From: Sarah Burrow <Sarah.Burrow@arun.gov.uk>
Sent: 25 August 2021 12:08
To: Planning.Responses <Planning.Responses@arun.gov.uk>
Cc: Andrew Wood <Andrew.Wood@arun.gov.uk>
Subject: RE: Planning Consultation on: CM/17/21/PL

Engineers Comments Regarding Surface Water Drainage

Application No: CM/17/21/PL
Registered: 16th April 2021
Site Address: Land at Wren Cottage Horsemere Green Lane Climping BN17 5QZ
Grid Reference: 499689 102182
Category: Plan Applicat'n
Description of Works: Development of 2 No. 2-bed & 2 No. 3-bed detached dwellings & associated works (resubmission following CM/53/20/PL). This site is in CIL Zone 3 & is CIL Liable as new dwellings.

SITE PLAN
SCALE 1:500 @ a3

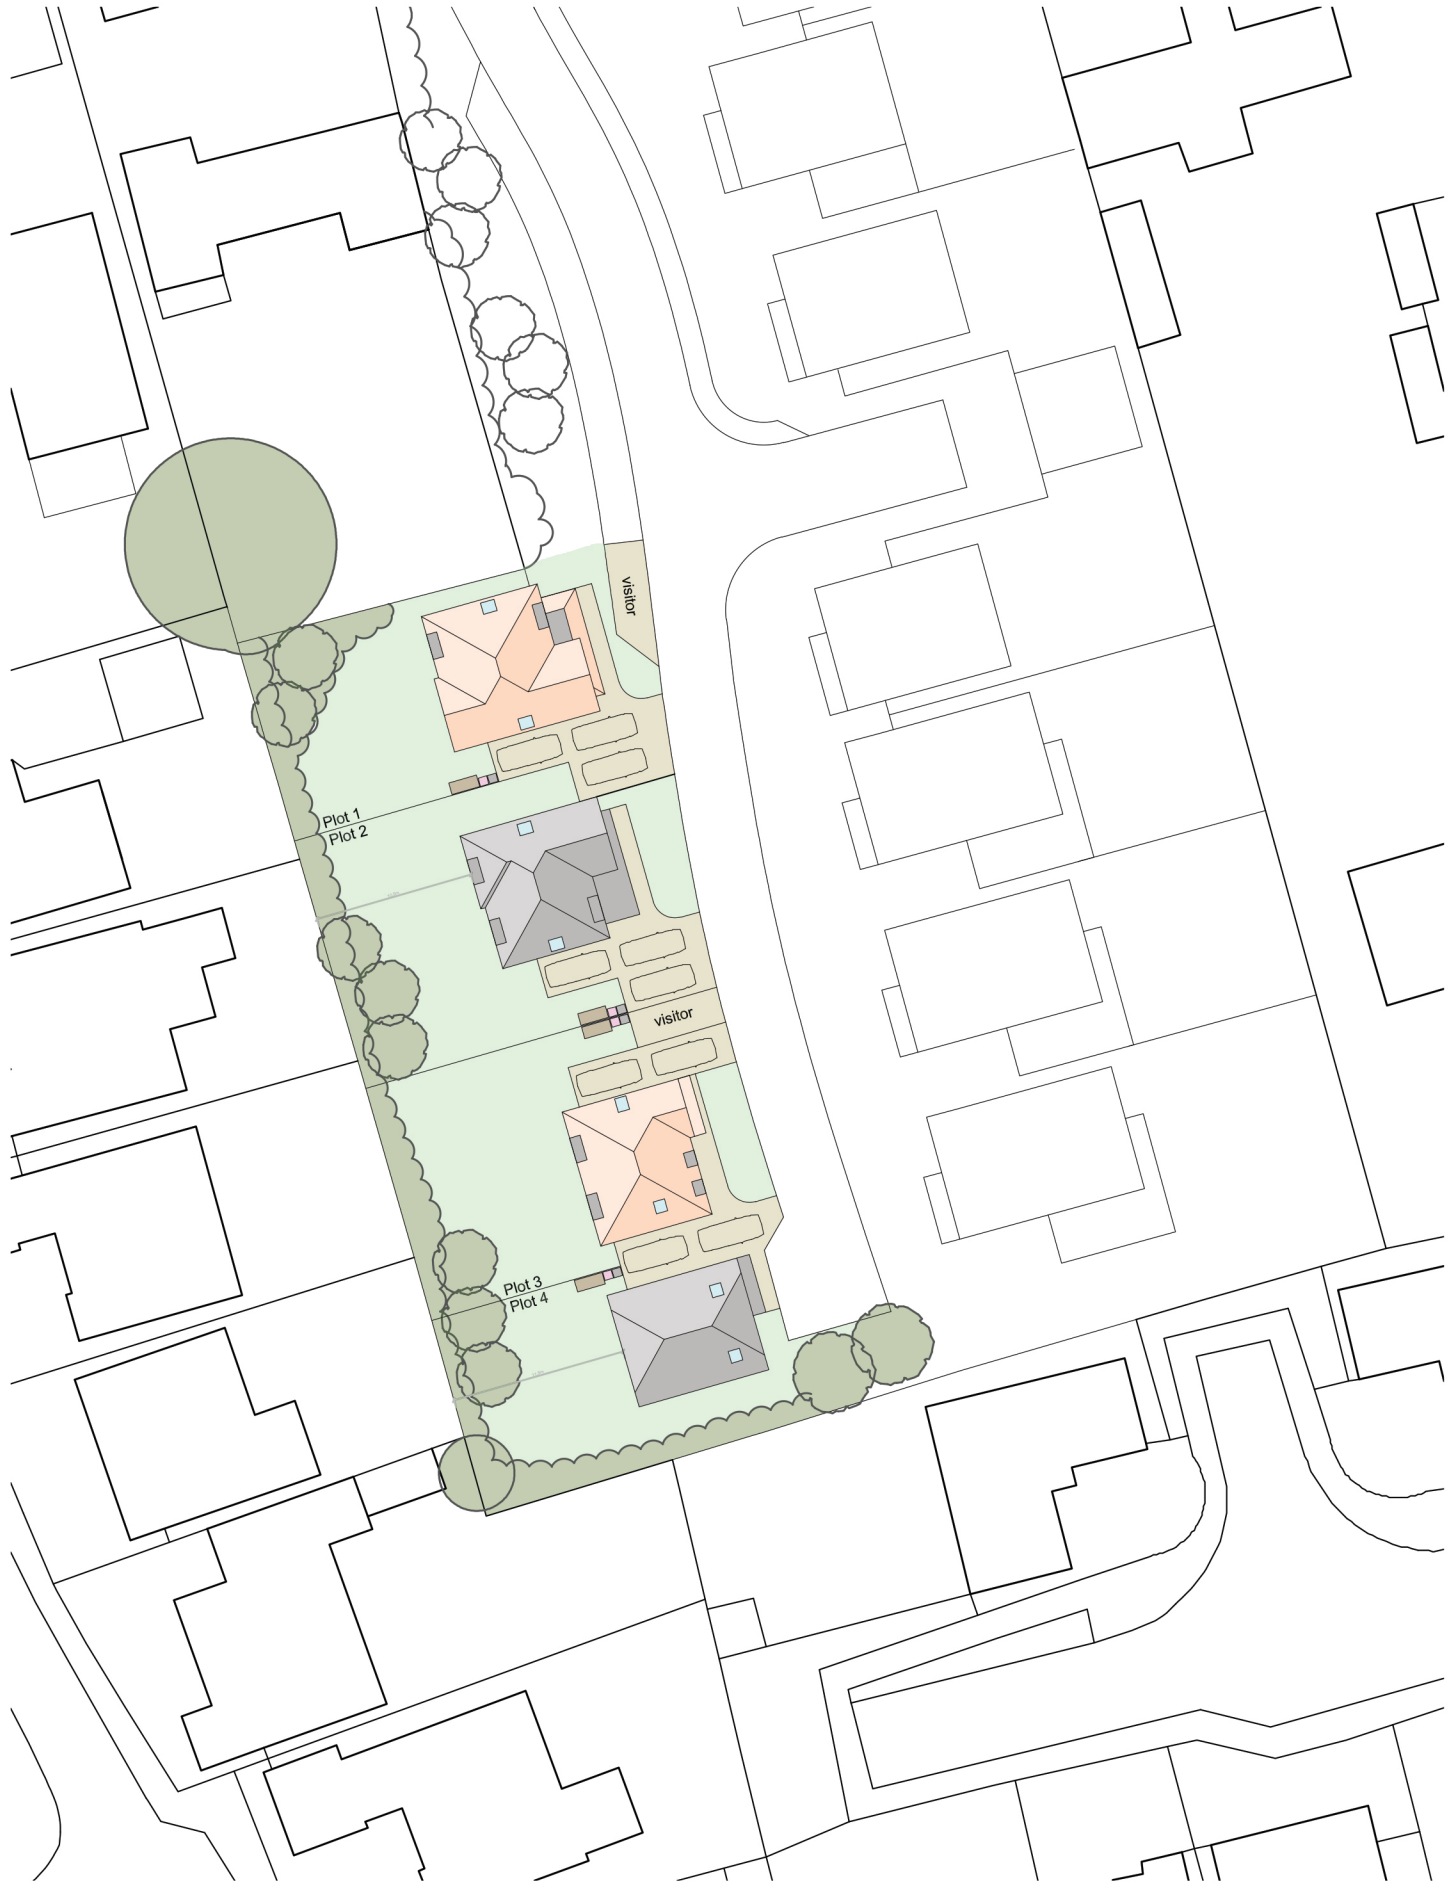
It is worth noting that our mapping shows a foul water sewer crossing the proposed site in the area of the extension. Please consult Southern Water regarding this.
